Your ref: SSD12_5705
File: 12/19185-1
30 January 2013

**TOLL IPEC Freight Transport Warehouse and Distribution Centre (SSD12_5705)
Bungarribee Industrial Estate, Eastern Creek, Blacktown Local Government Area**

Conditions of consent – TOLL IPEC Bungarribee Industrial Estate, Eastern Creek

01 SIGNAGE SCHEDULE 1102

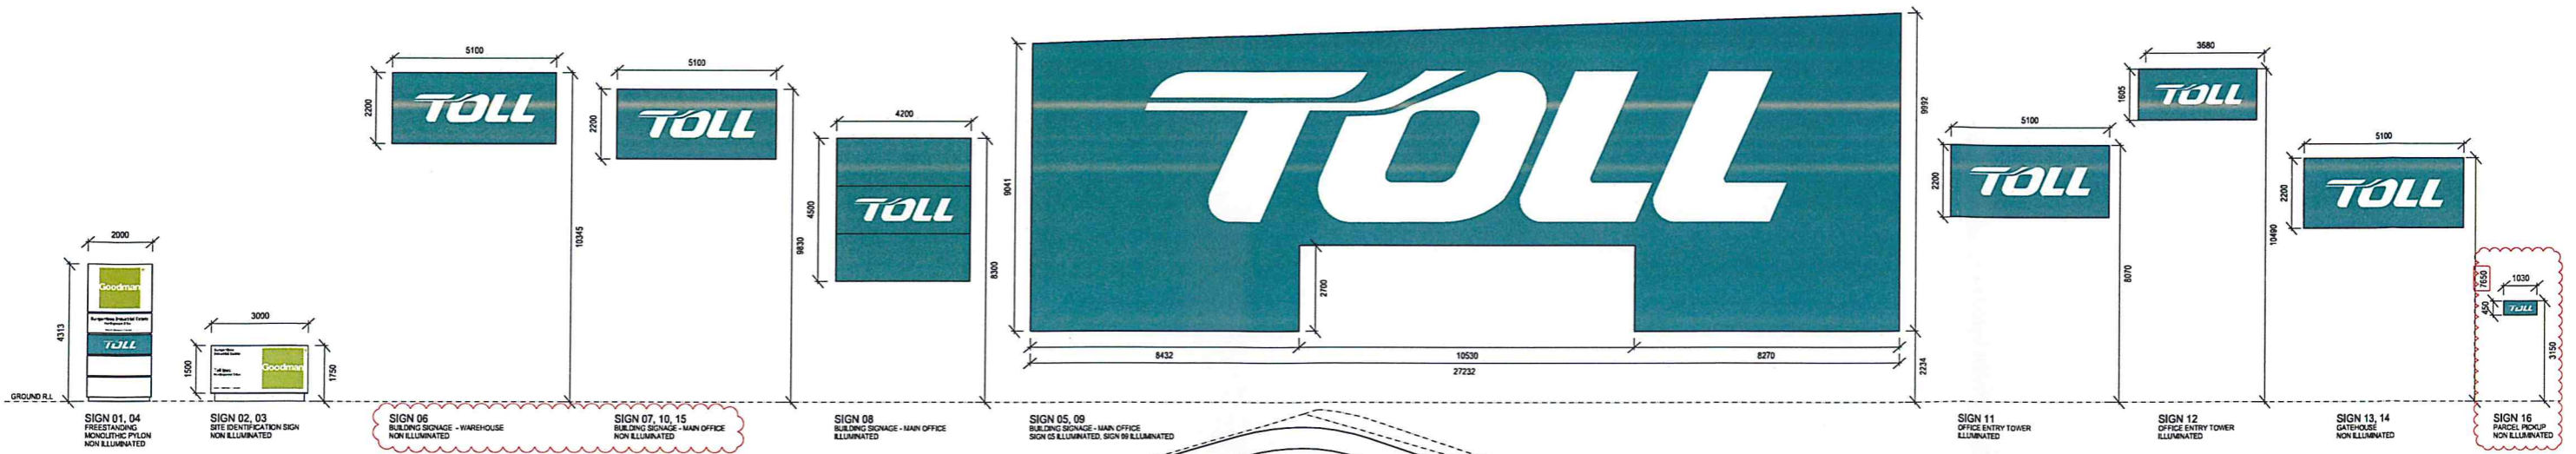
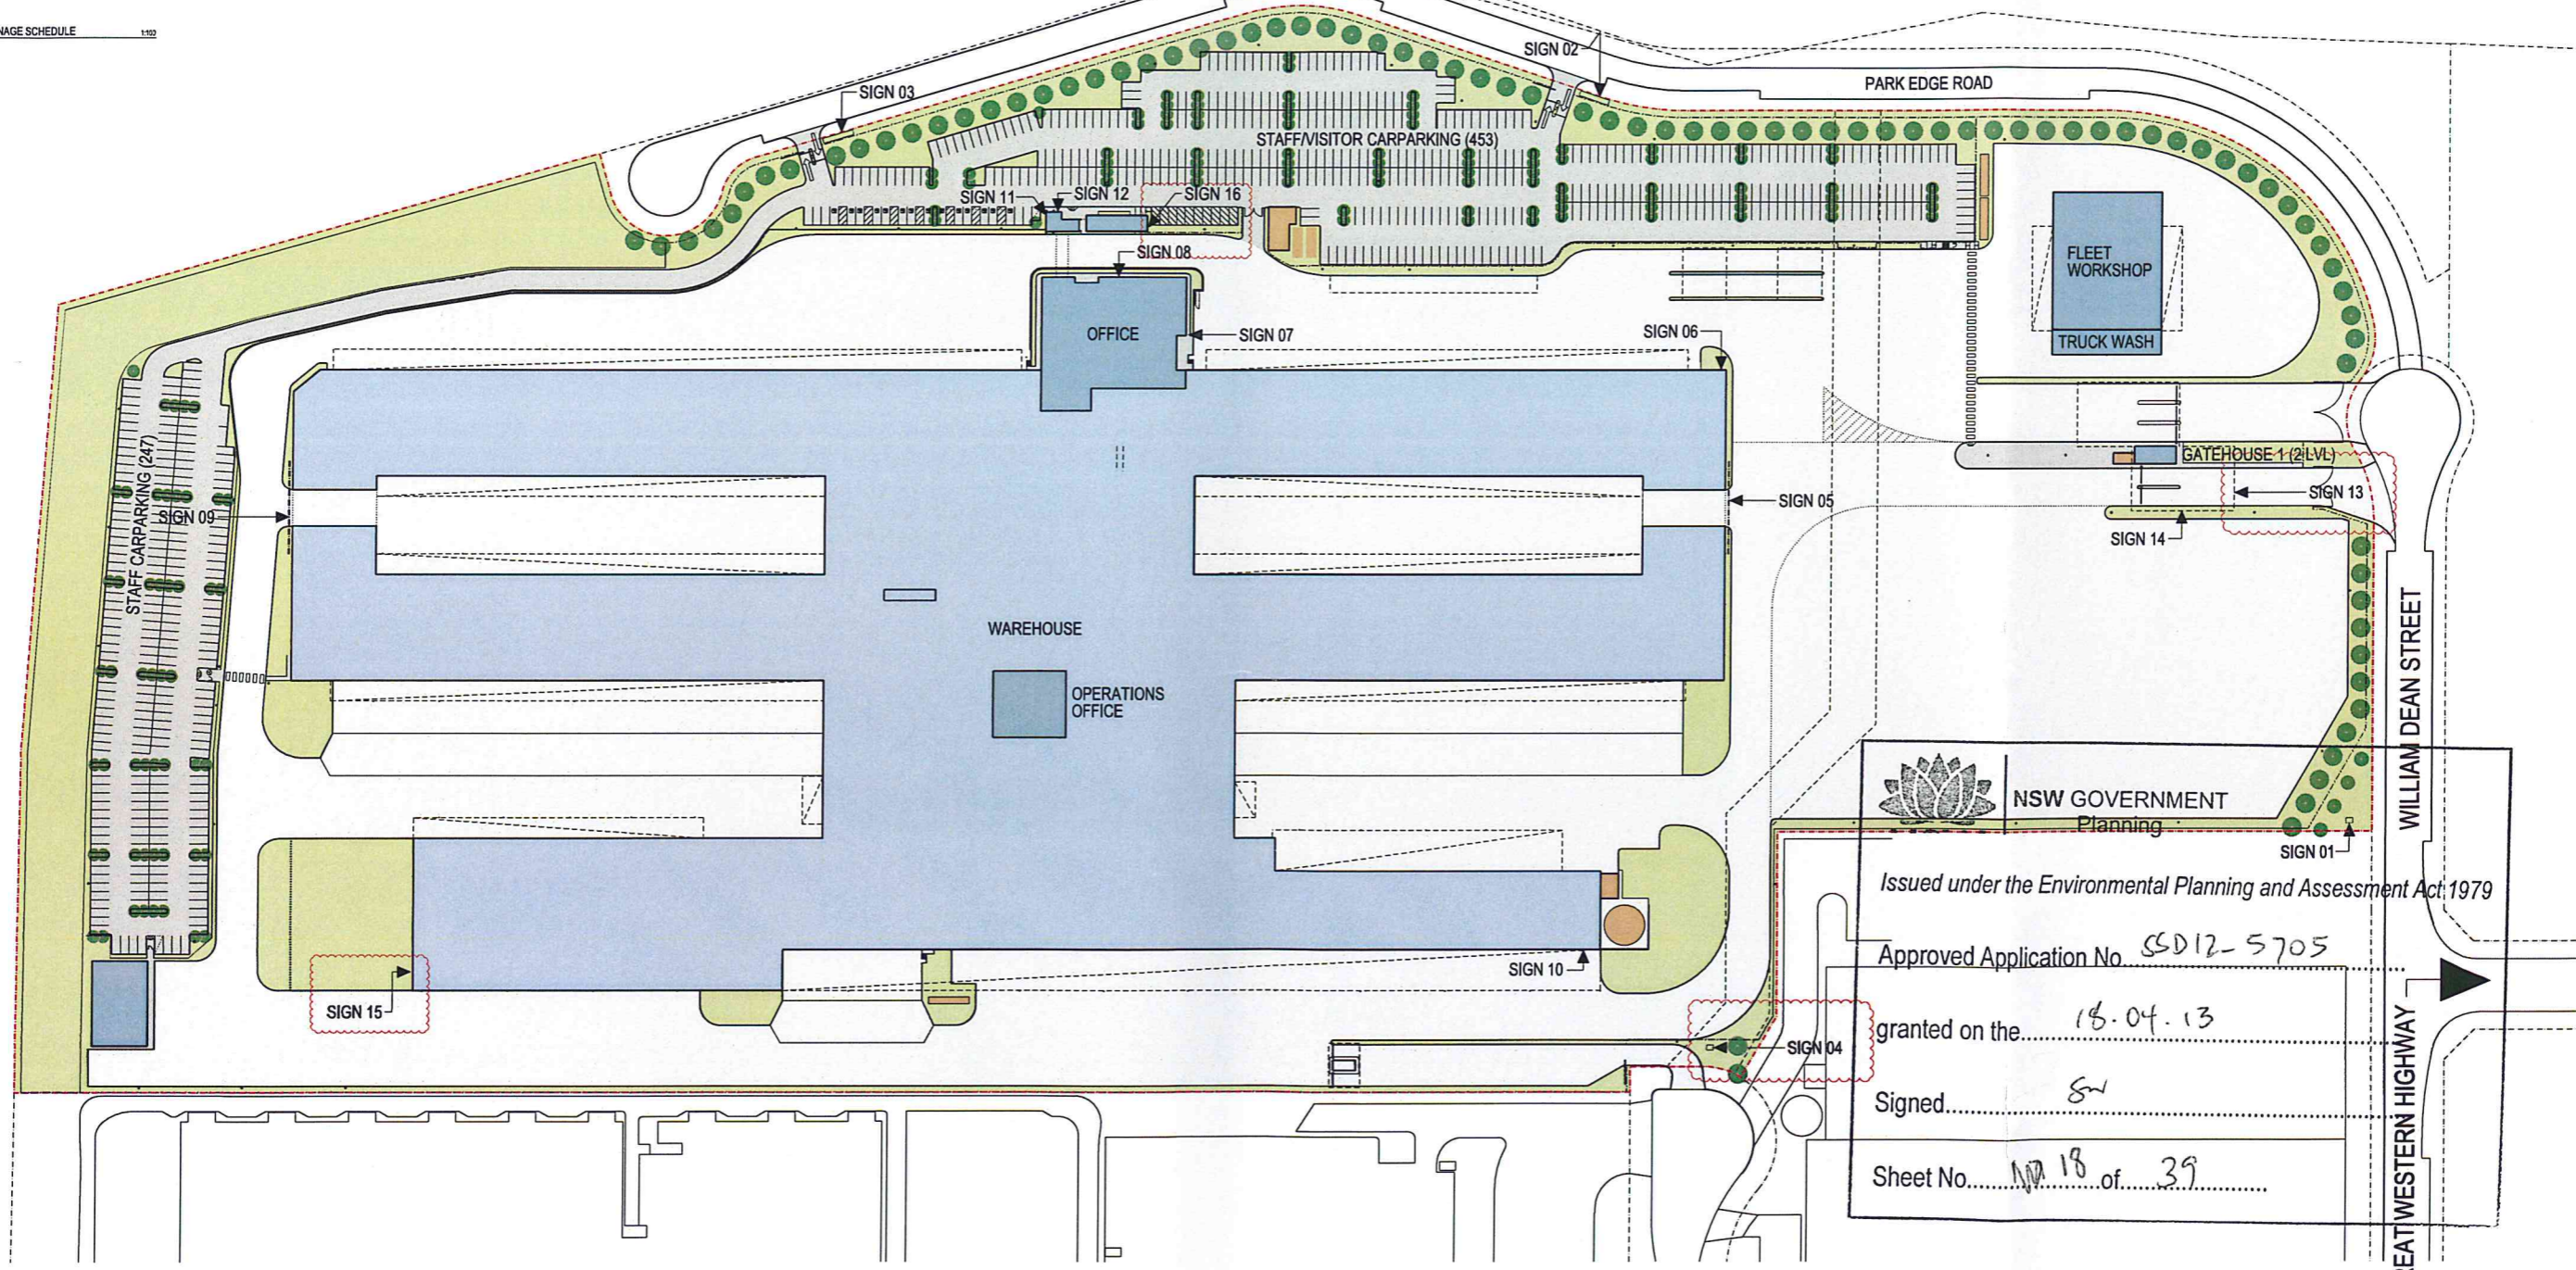
- 3.5.1 In accordance with point 4.6.9 Appendix D of the Environmental Assessment Report, all directional signage is to be detailed prior to release of a Construction Certificate to ensure safety is maintained within the site. Entrance/exit points are to be clearly signposted and visible from the street and the site at all times. Off-street car parking shall also be encouraged by the installation of appropriate, permanent and prominent signs indicating its availability. In this regard, appropriate signage should direct motorists to the Park Edge Road entrance.
